A303 Sparkford to Ilchester Dualling Scheme TR010036

6.3 Environmental Statement Appendix 4.2 Scoping Opinion Schedule of Comments and Responses

**6.3 Environmental Statement
Appendix 4.2 Scoping Opinion Schedule of Comments and
Responses**

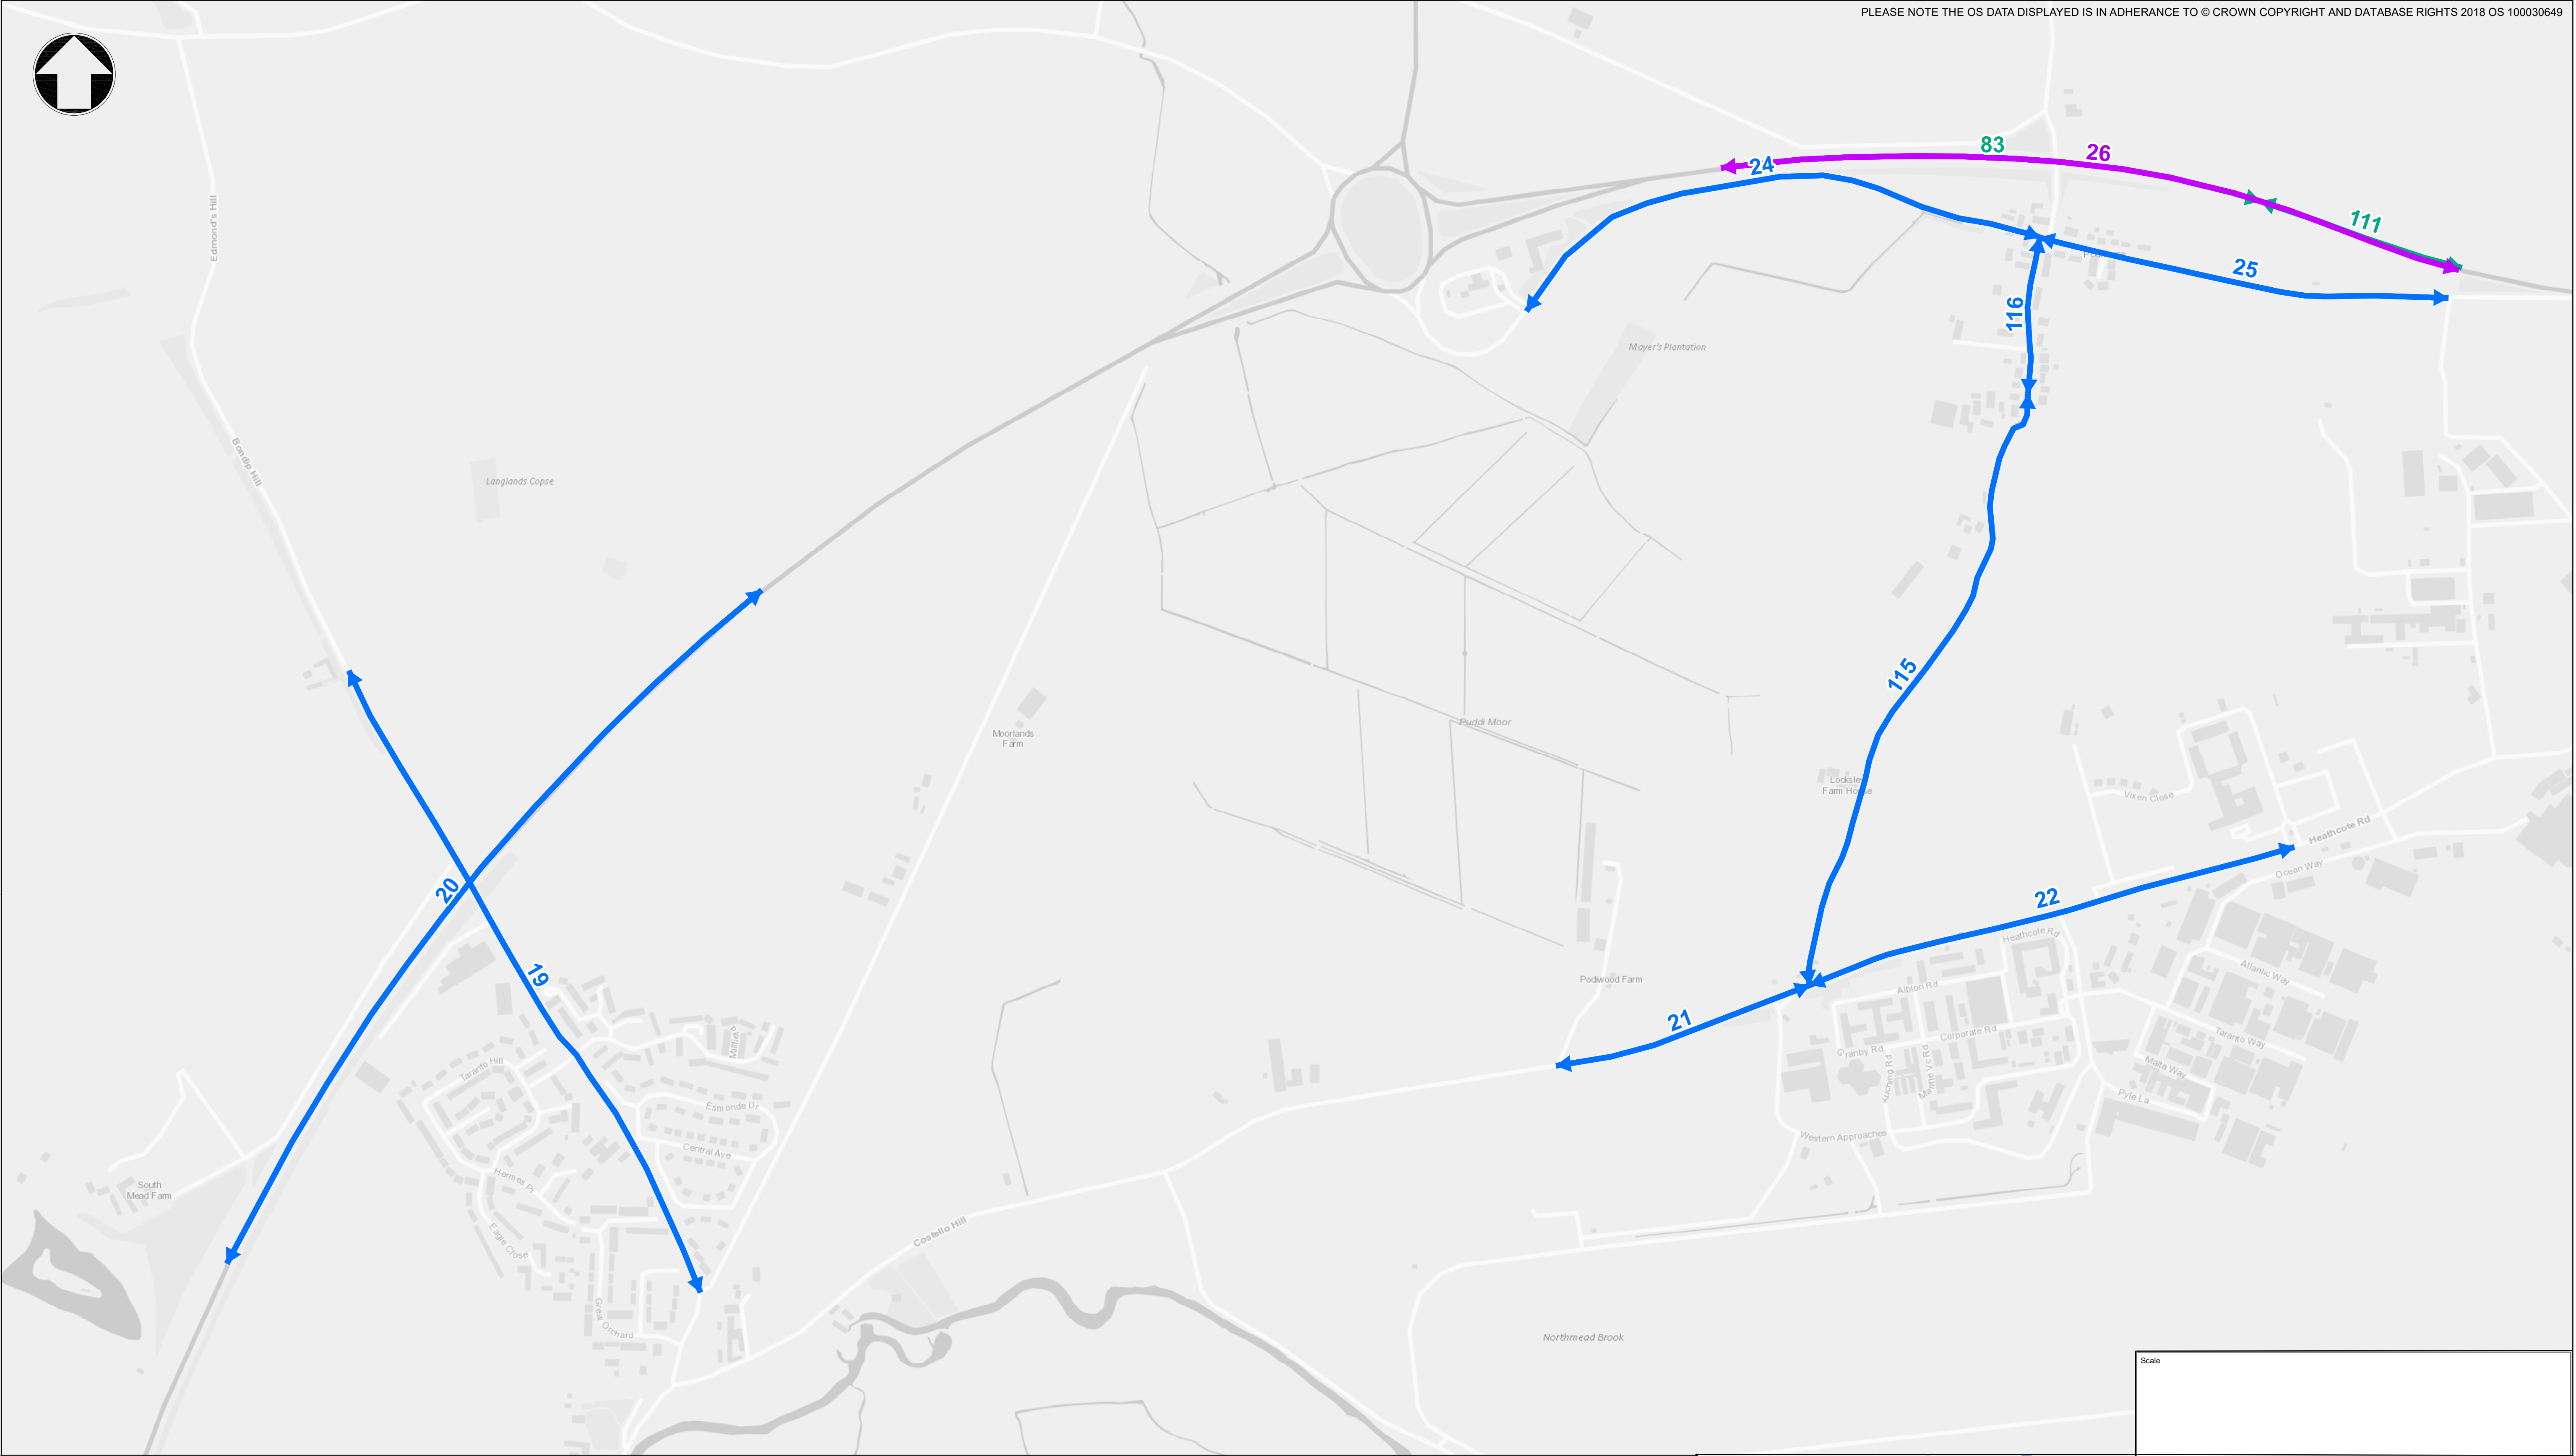
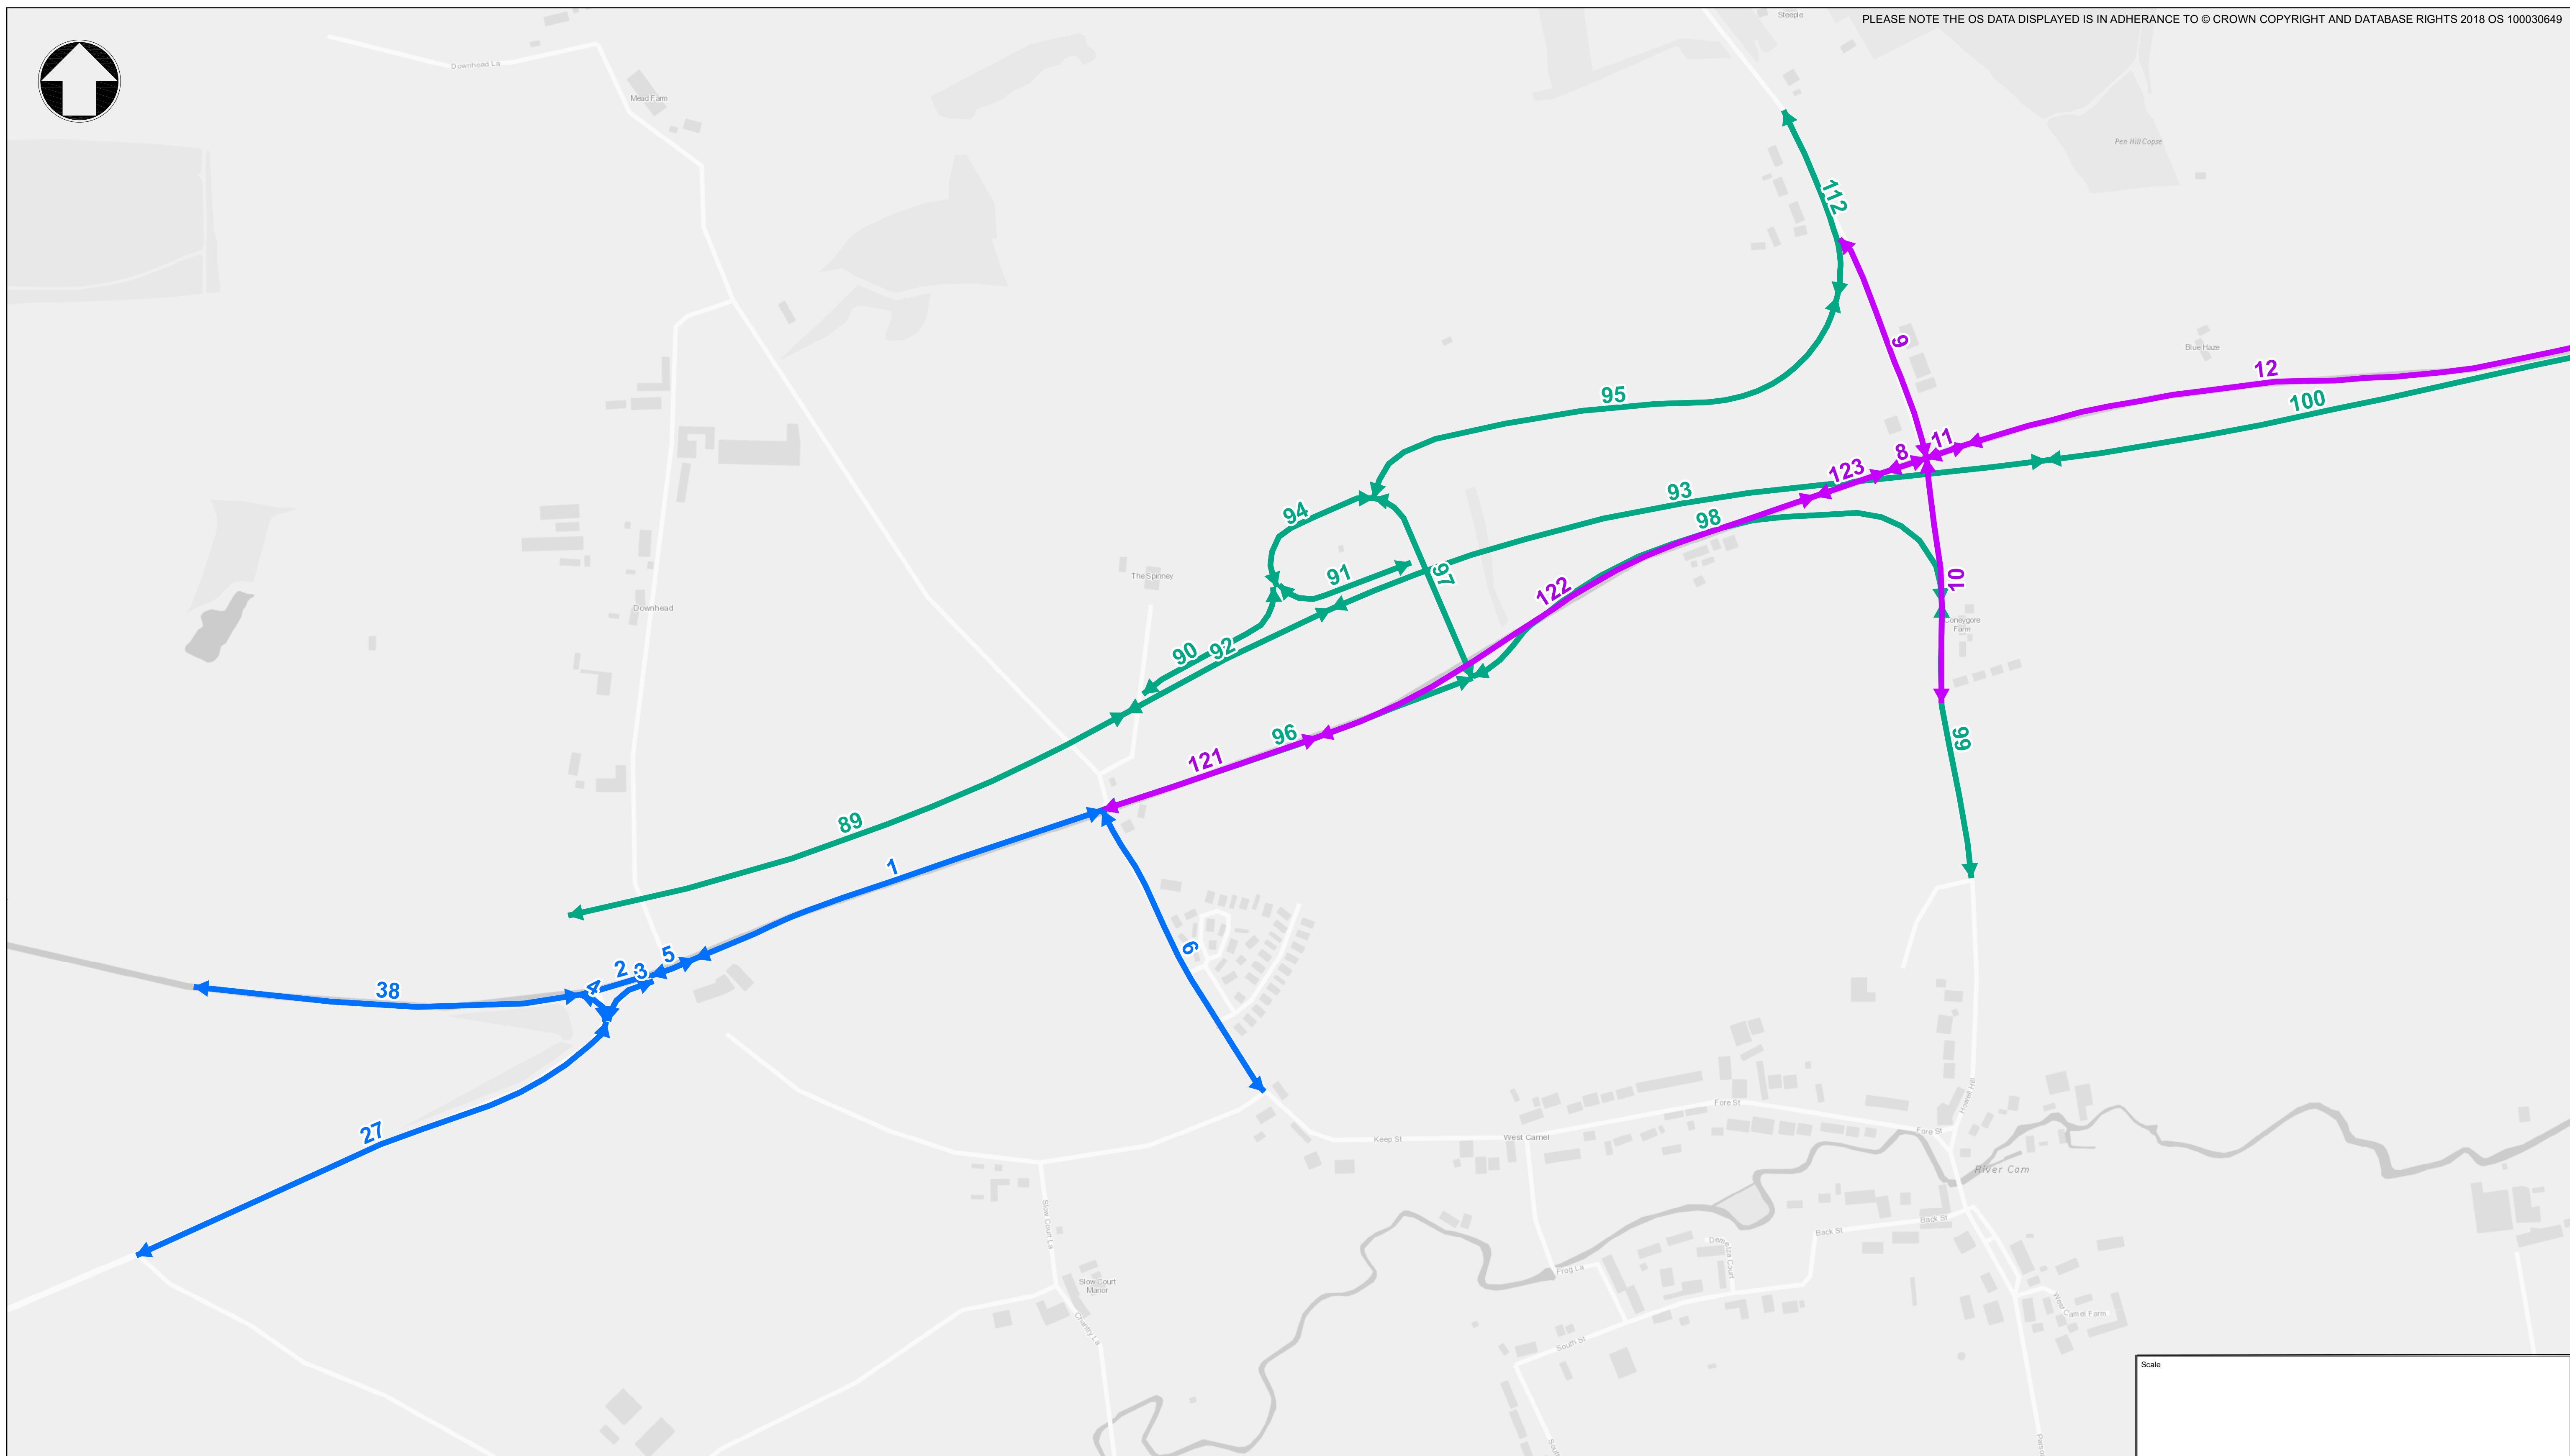
ID 3	PINS	<i>Study area</i> - The ES should include a plan or figure to depict the extent of the ARN and identify the sensitive receptors; both human and ecological which may be impacted by the Proposed Development.	A figure to be included within the ES of the ARN and nearby sensitive receptors.	Figure 5.2 shows the Local ARN, 5.5 shows the Regional ARN, and Figure 5.4 shows the air quality receptors (both air quality and ecological) considered within Chapter 5 Air Quality, Volume 6.1.
ID 4	PINS	<i>Baseline</i> - The Scoping Report identifies that diffusion tube monitoring has taken place over 6 months at 16 locations along roads near the Proposed Development. The dates of these surveys, together with the locations and justification of why the locations were selected should be included within the ES.	Additional information related to the monitoring survey undertaken to be included in the ES.	Appendix 5.2 Monitoring Survey (Volume 6.3) has been produced to provide additional details on the diffusion tube monitoring undertaken.
